From: Ian Stocks [REDACTED] **On Behalf Of** FRS Water and Access
Sent: 14 December 2021 08:06
To: Planning.Responses <Planning.Responses@arun.gov.uk>
Subject: Hydrant condition - CM/70/21/PL Land at Wren Cottage Horsemere Green Lane Climping BN17 5QZ

HYDRANT CONDITION CONSULTATION WITH PLANNING AUTHORITY

Planning Ref: CM/70/21/PL

Description: Subdivision of the plot and construction of 3 detached bungalows with associated parking, access and landscaping (resubmission of CM/17/21/PL). This application is in CIL Zone 3 and is CIL Liab as new dwellings.

Proposed Site Plan

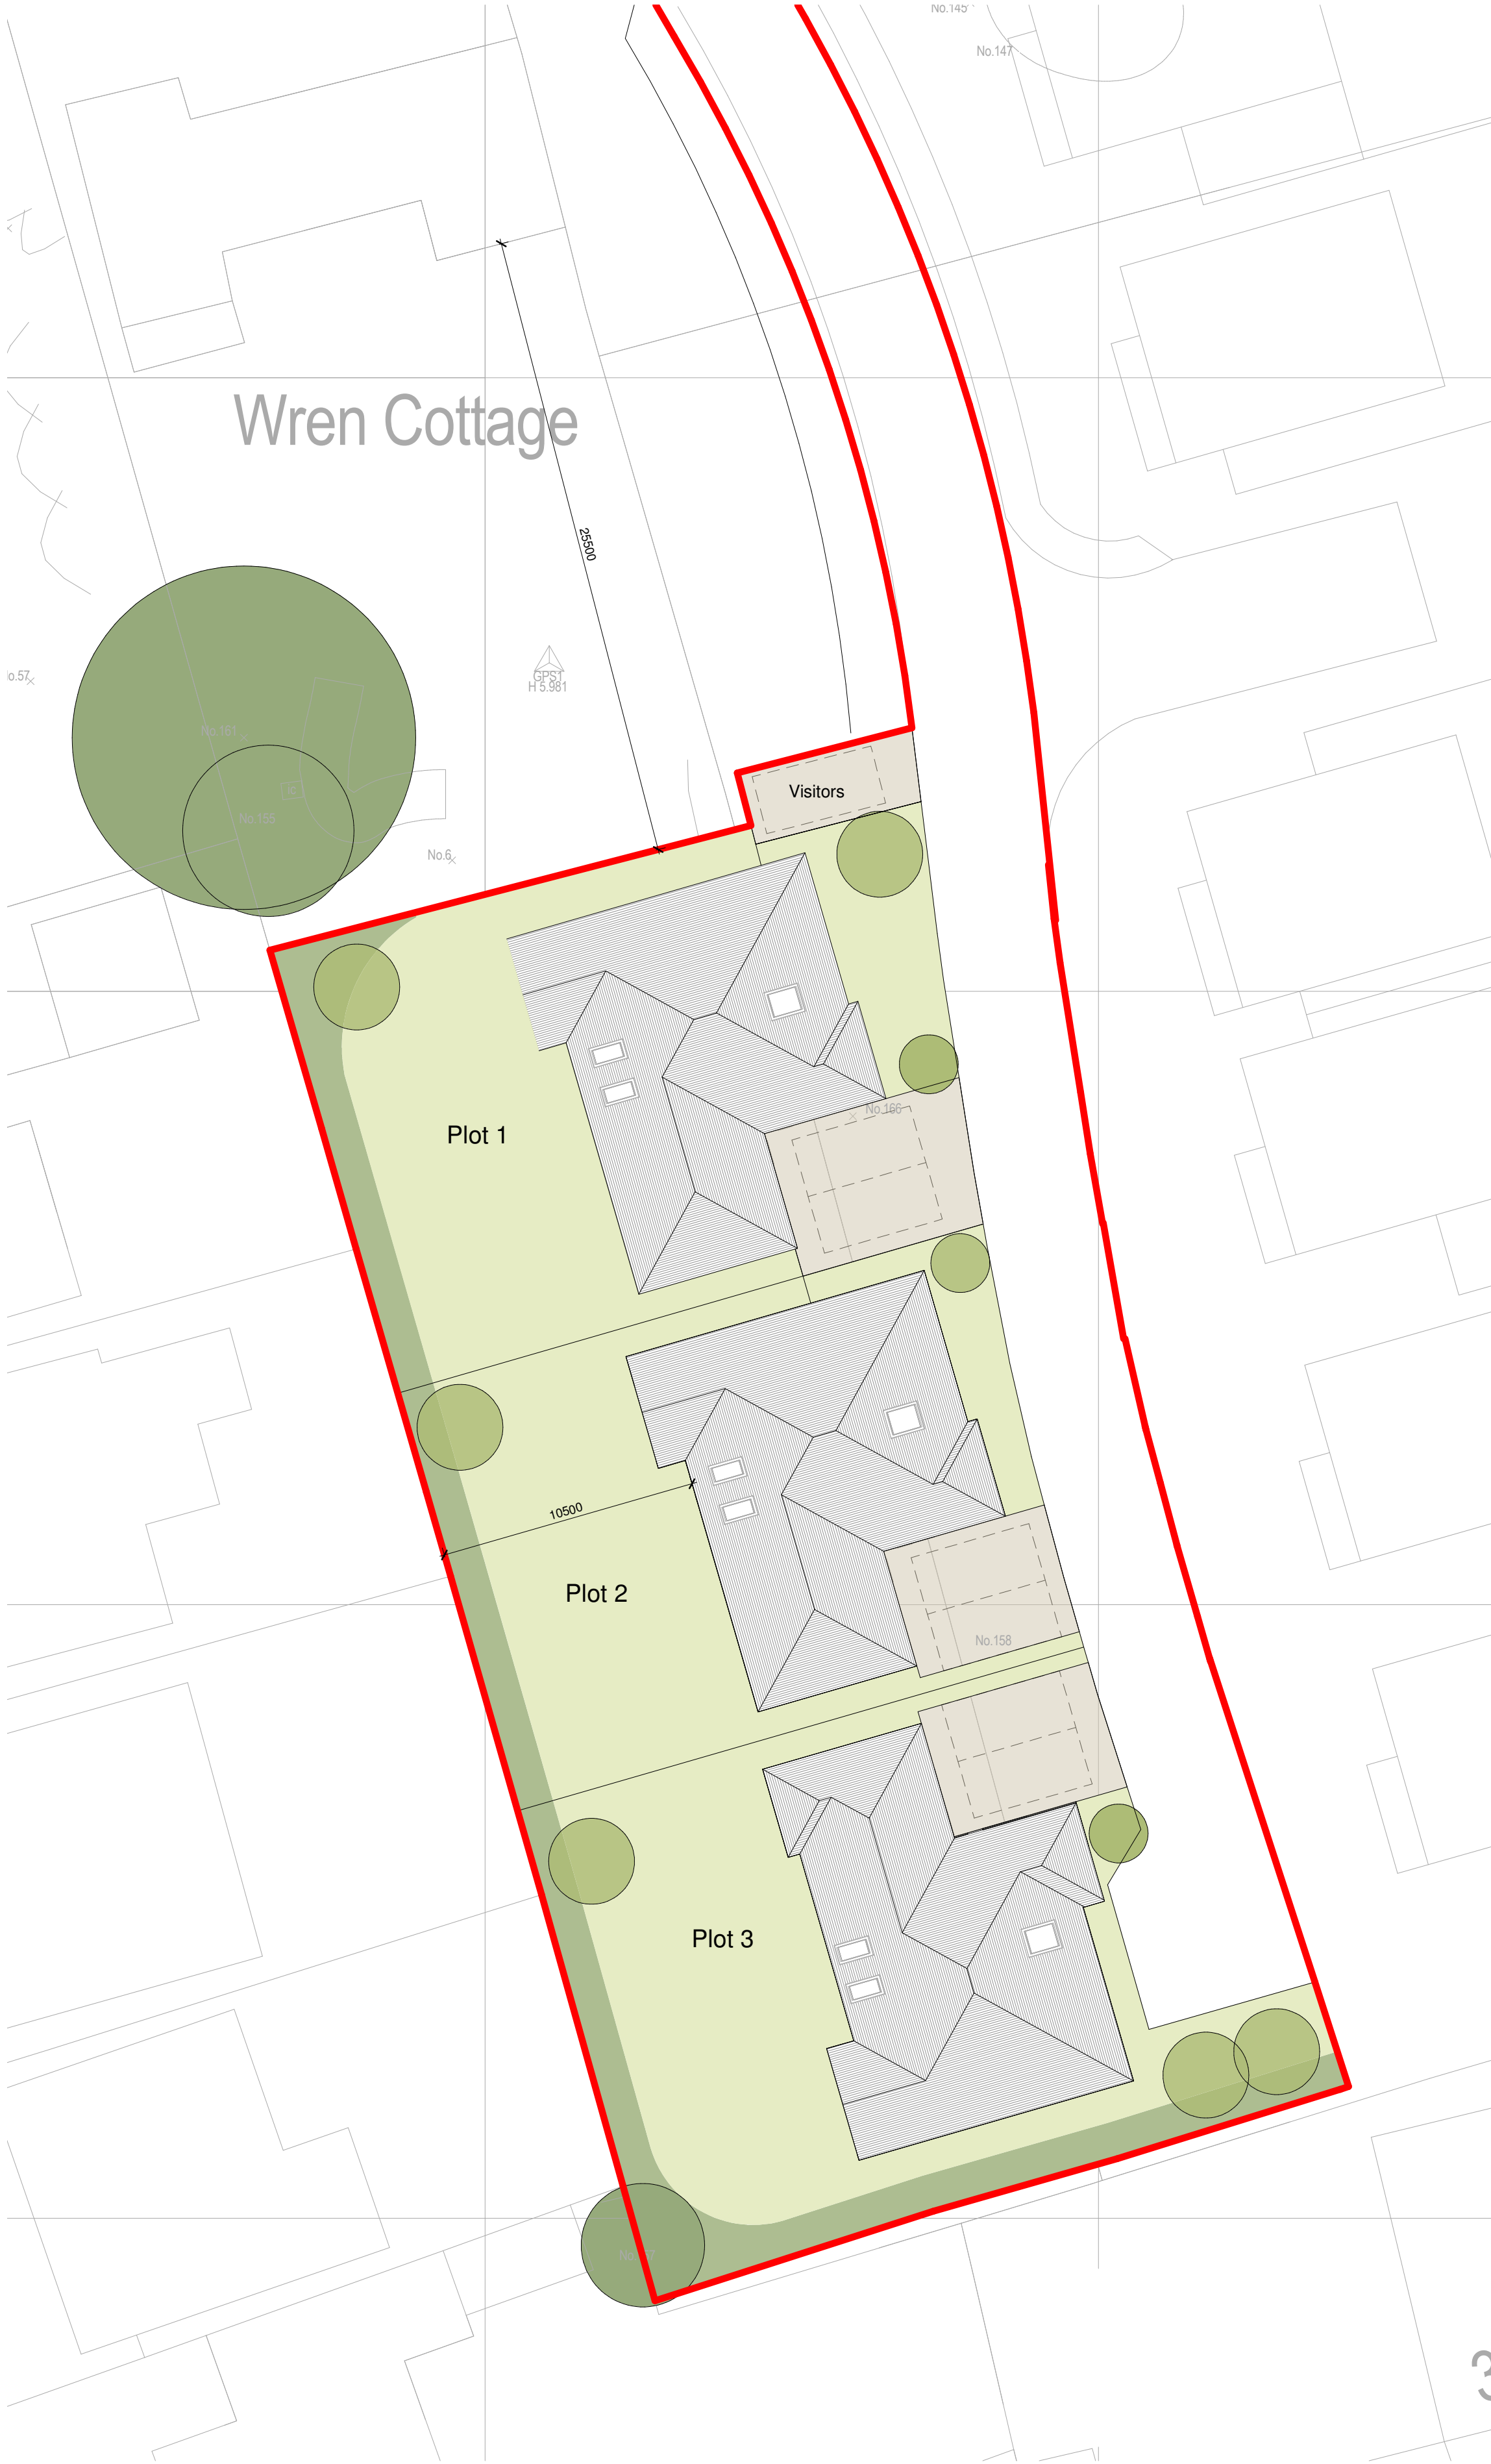
Please find attached a planning condition for application no. CM/70/21/PL for the requirement of an additional fire hydrant. Currently the nearest Hydrant to these proposed properties is 250 metres away. The supply of water for firefighting for a domestic premises should be within 175 metres.

Evidence will also be required that Fire Service vehicle access meets with the requirements identified in Approved Document B Volume 1 2019 Edition: B5 Section 13, including Table 13.1 and diagram 13.1. From the plans submitted there does not appear to be sufficient turning facility for a fire appliance to make an exit without needing to reverse more than 20 metres.

- 1) Prior to the commencement of the development details showing the proposed location of [1] one fire hydrant or stored water supply (in accordance with the West Sussex Fire and Rescue Guidance Notes) shall be submitted to and approved in writing by the Local Planning Authority in consultation with West Sussex County Council's Fire and Rescue Service. These approvals shall not be unreasonably withheld or delayed.
- 2) Prior to the first occupation of any dwelling/unit forming part of the proposed development that they will at their own expense install the fire hydrant (or in a phased programme if a large development) in the approved location to BS 750 standards or stored water supply and arrange for their connection to a water supply which is appropriate in terms of both pressure and volume for the purposes of firefighting.
